KITTITAS COUNTY

DEPARTMENT OF PUBLIC WORKS

MEMORANDUM

TO: All Staff
FROM: Public Works Plan Review Team
DATE: December 20, 2022
SUBJECT: CU-22-00004 Events at Brickhouse Nursery

**SITE PLAN 11x17
EVENT USE**

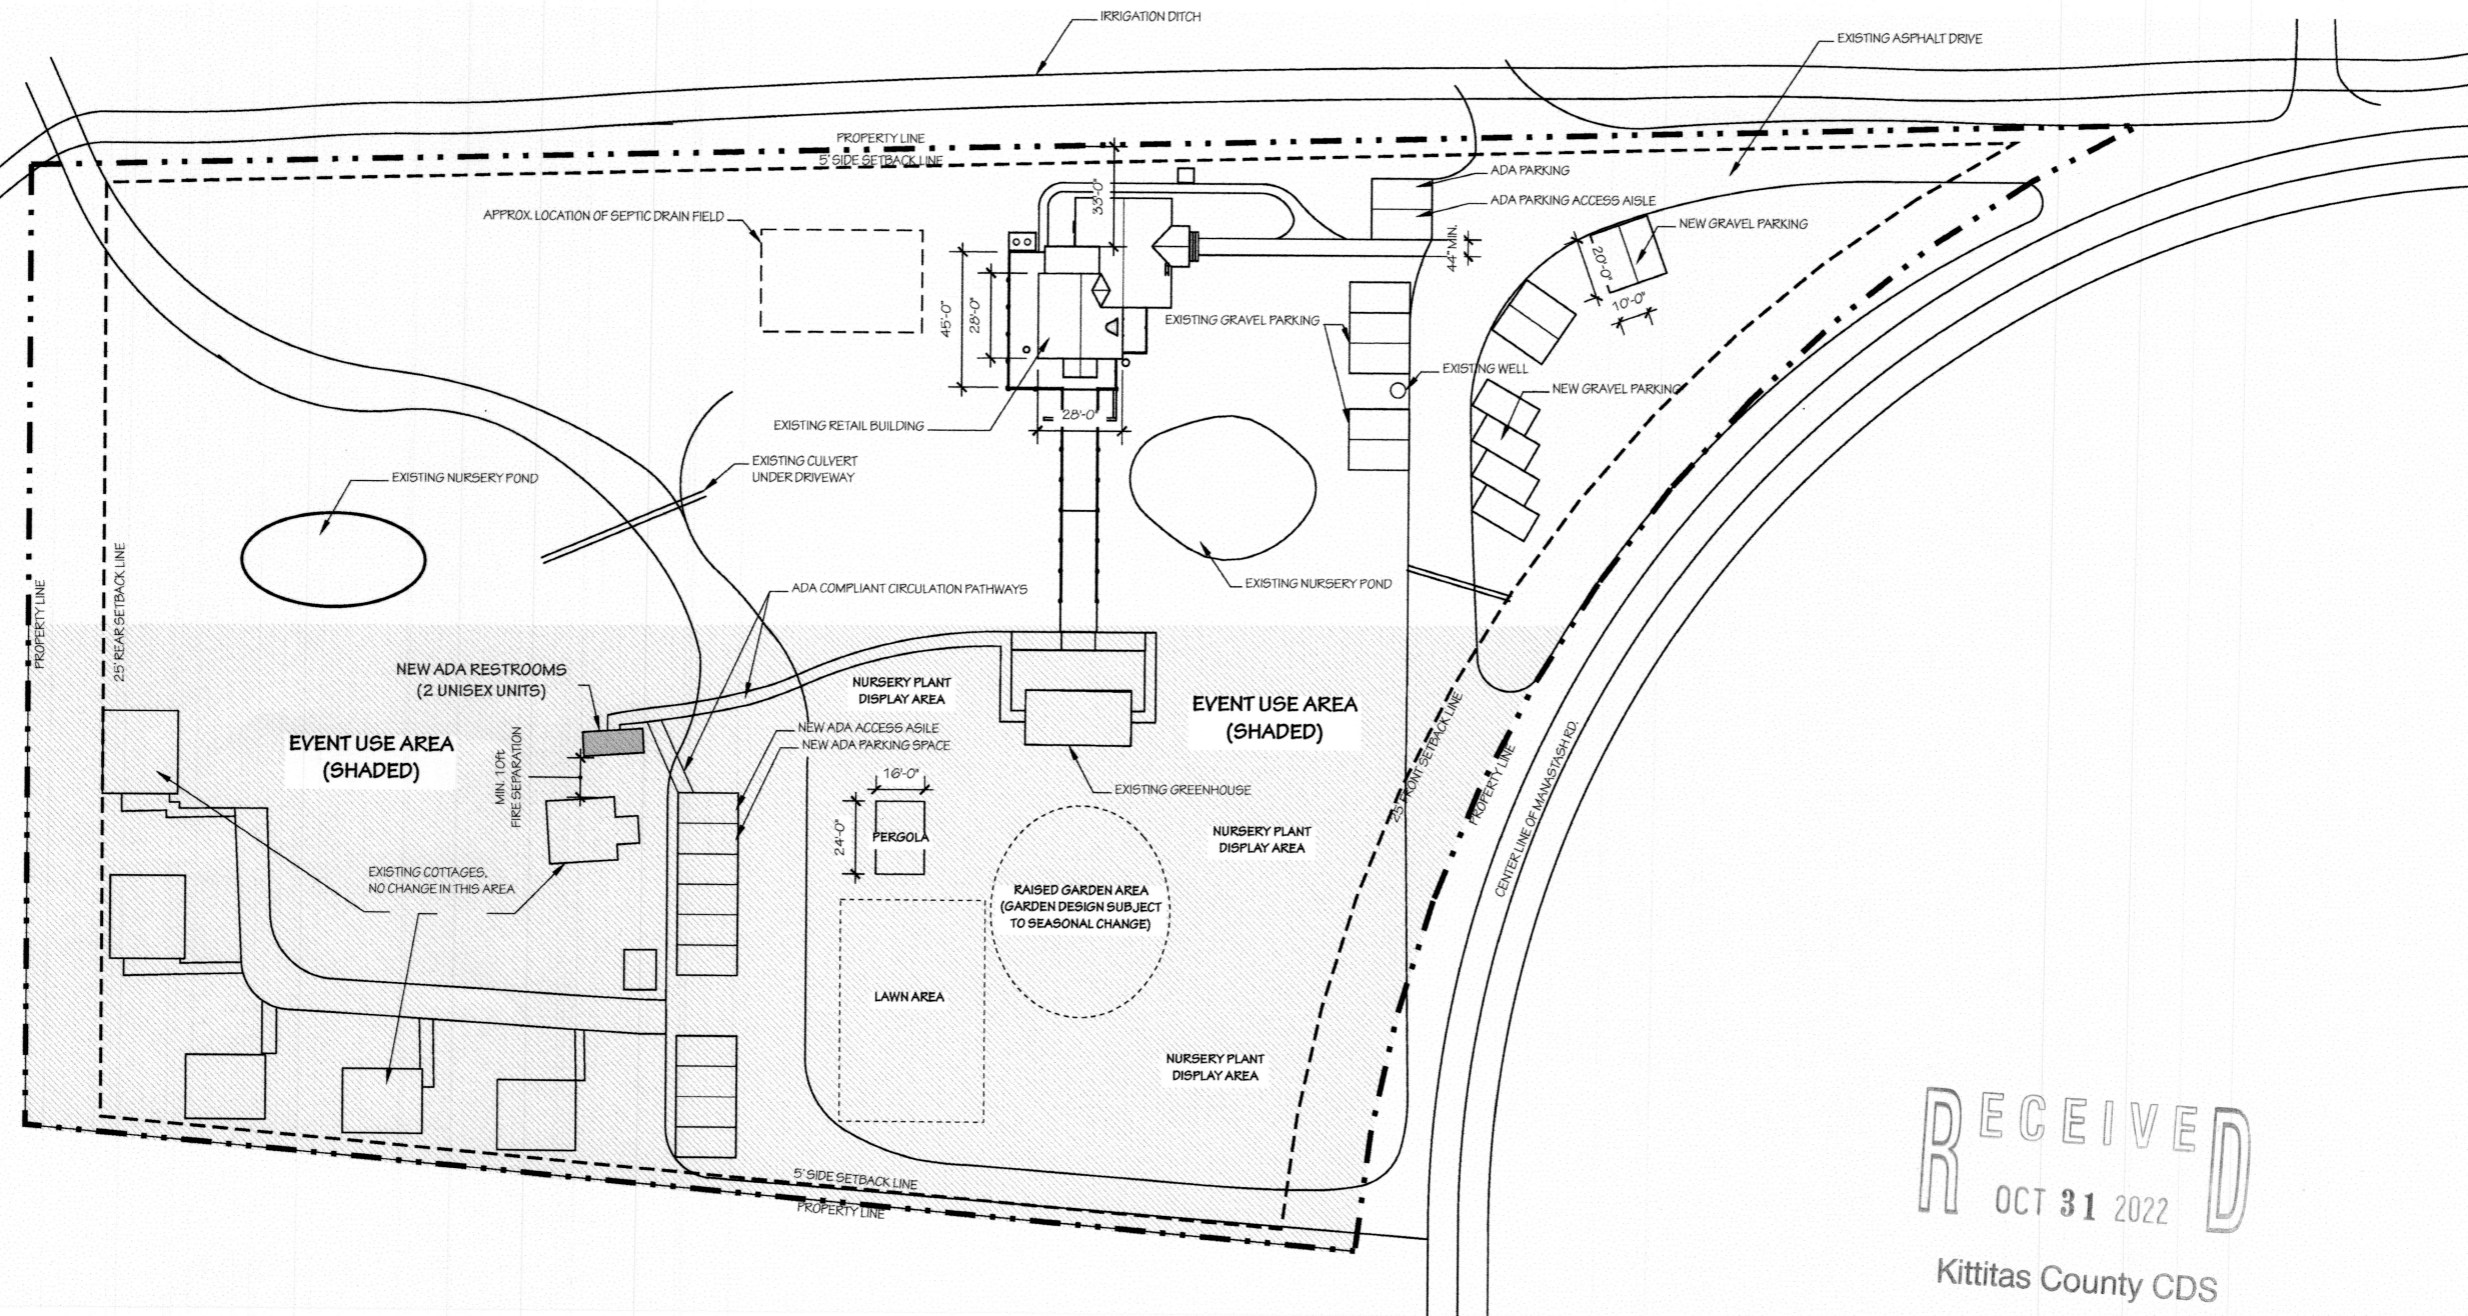
ACCESS	Access requirements met per AC-22-00028.
ENGINEERING	<ol style="list-style-type: none">1. Except as exempted in Section KCC 14.05.060, no grading or filling upon a site involving more than one hundred (100) cubic yards shall be performed without a grading permit from the County Engineer or Public Works designee (KCC 14.05.050). An application for grading in excess of five hundred (500) cubic yards shall be accompanied by an engineered grading plan (KCC 14.05.080).2. Traffic Concurrency is required for all land use actions. A transportation impact analysis (TIA) shall be required for all development that will generate more than nine (9) peak hour vehicle trips. Please provide estimated traffic generation for peak hours to determine if a TIA will be required. (KCC 12.10.040(c))
SURVEY	All attempts shall be made to protect the survey monument marking the NW corner of Section 13 located near the proposed parking area. In the event this monument is disturbed or destroyed, it shall be replaced by a land surveyor licensed in the State of Washington. (JT)
